Re: Comments regarding Rampart Row Short Plat (SP-19-0002) application

Please consider the following comments regarding the Rampart Row Short Plat (SP-19-0002) development application.

RAMPART ROW SHORT PLAT APPLICATION

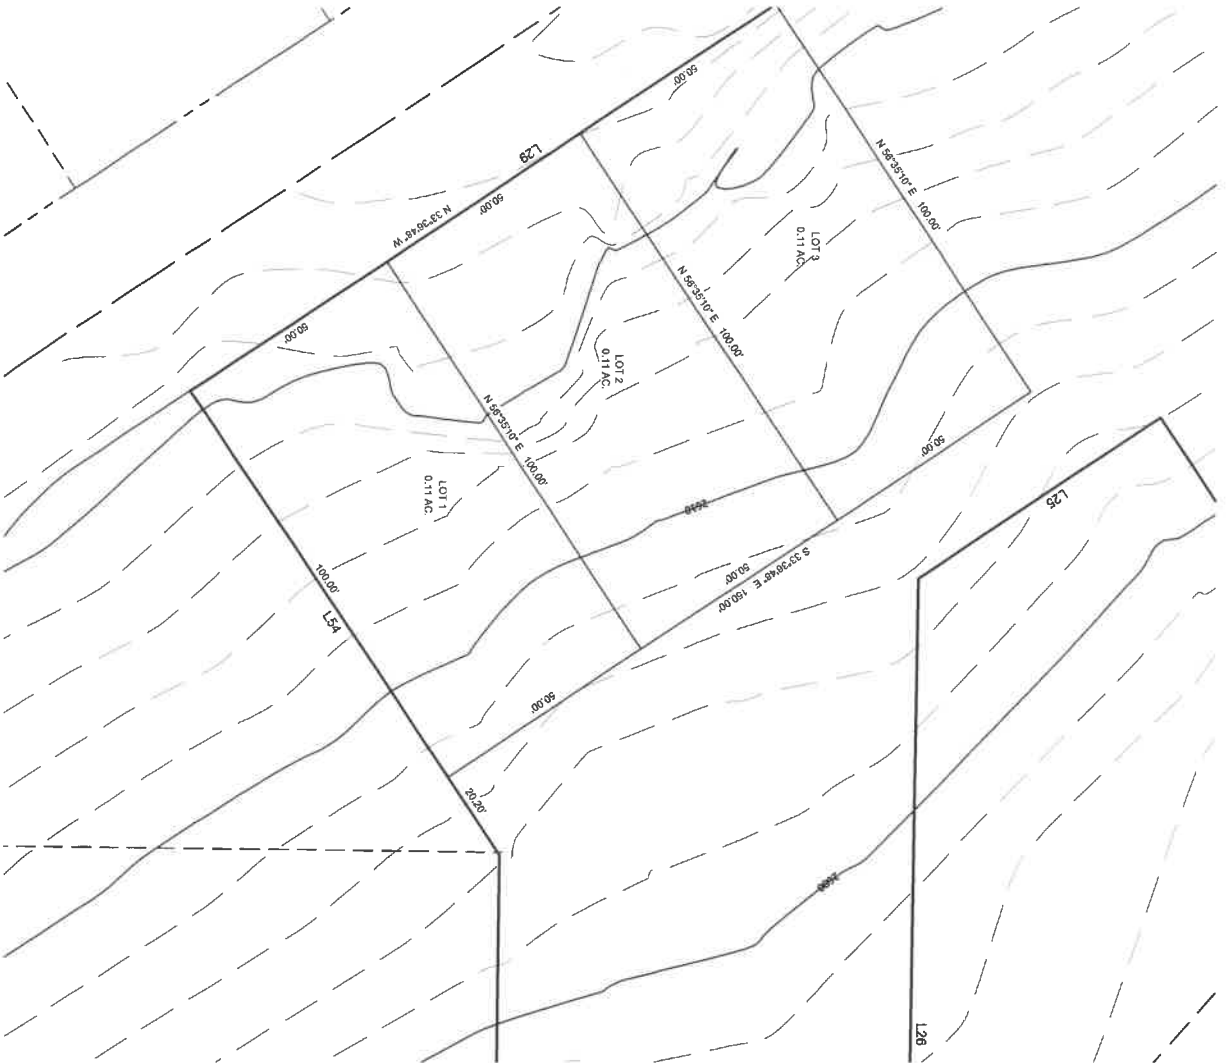
My family and I own the two parcels directly across the street from Lots 1-3 in this proposed short plat. Our property is address 490 Rampart Dr., Parcel Number 138635. From looking at the proposed site plan, it appears that homes on these parcels will directly block our view of the mountains. As one of the conditions for approval, I propose that a 16'-0" height limit be imposed on the structures to be built on these parcels along Rampart Dr., from the highest point of natural grade from within the building setbacks, so that the new homes do not block the views from our home and the other homes across the street from them within Hyak Estates. A 16'-0" height limit is typical for view sensitive areas, such as the City of Gig Harbor, and other jurisdictions within the State of Washington. In addition, I would propose that a minimum interior side yard setback of 10'-0" be one of the conditions, which would provide a minimum 20' view corridor between proposed buildings.

Another issue is the proposed density and lot size. The Hyak Estate lots on Rampart are approximately 0.25 acre each (4 units to the acre). The proposed lot sizes in the short plat appear to be 0.11 acre each (9-10 units to the acre), which is more than twice the density, and out of scale from, the Hyak Estate neighborhood. The proposed lots are 50' wide; whereas our lots across the street in Hyak Estates are each 65' wide. There will be three (3) new driveways accessing homes directly in front of our property. Since these proposed parcels are sharing the Hyak Estates road, and becoming part of the Hyak Estates neighborhood, which has strong design guidelines, then these lots should be in proportion to the scale, size, shape and size of the Hyak Estates lots. This will ensure consistency of structure sizes, preservation of property values, and reduce impact to existing services, utilities, water, storm water run-off and traffic. In addition, they should be held to the same architectural design standards that are required in Hyak Estates.

Rampart Drive is one of the last roads to receive snow removal plowing service, after a snow event; therefore, additional on-street parking should not be allowed on Rampart. Additional parking and driveways right across the street from us will be hazardous to our ability to come out of our driveway safely. It is already an issue when the road hasn't been plowed, and icy conditions exist. Will the county increase frequency of plowing with additional homes being permitted? Is off-street parking being provided for the new homes? Will the front setback off Rampart be large enough to accommodate parking on each proposed lot? As a condition of approval, the front setbacks to the proposed lots need to meet the setback standards and parking requirements already established for Hyak Estates, at a minimum, which I believe is 25'-0".

The area of the short plat is very wet, from natural spring water coming out of the hill. This is a concern for storm water, and geological preservation of the critical area hillside. When we and our neighbors constructed our homes, we had to divert excessive amounts of ground water around our foundations during and after construction, due to natural spring water coming out of the hillside. There are several open "streams" coming out of the hill between our house and our neighbor's houses. This would be another reason to require ample space between the proposed building envelope footprints, to allow for storm drainage easements. There is a storm easement between our house and our neighbor's house. Will this drainage easement continue to the other side of the street, along the south-east property line of Lot 1? What about on the side of Lot 3?

There was a recent avalanche on the Summit East's adjacent ski slopes a few years ago, which is part of the same hillside as Hyak Estates and the proposed development. Over-development of the hillside could compromise the natural flow of water and slope stability below our home, on the downhill side of Rampart drive. Are there any conditions included that will insist that future construction will abide by using Best Management Practices and erosion control measures to prevent erosion and to provide slope stability?
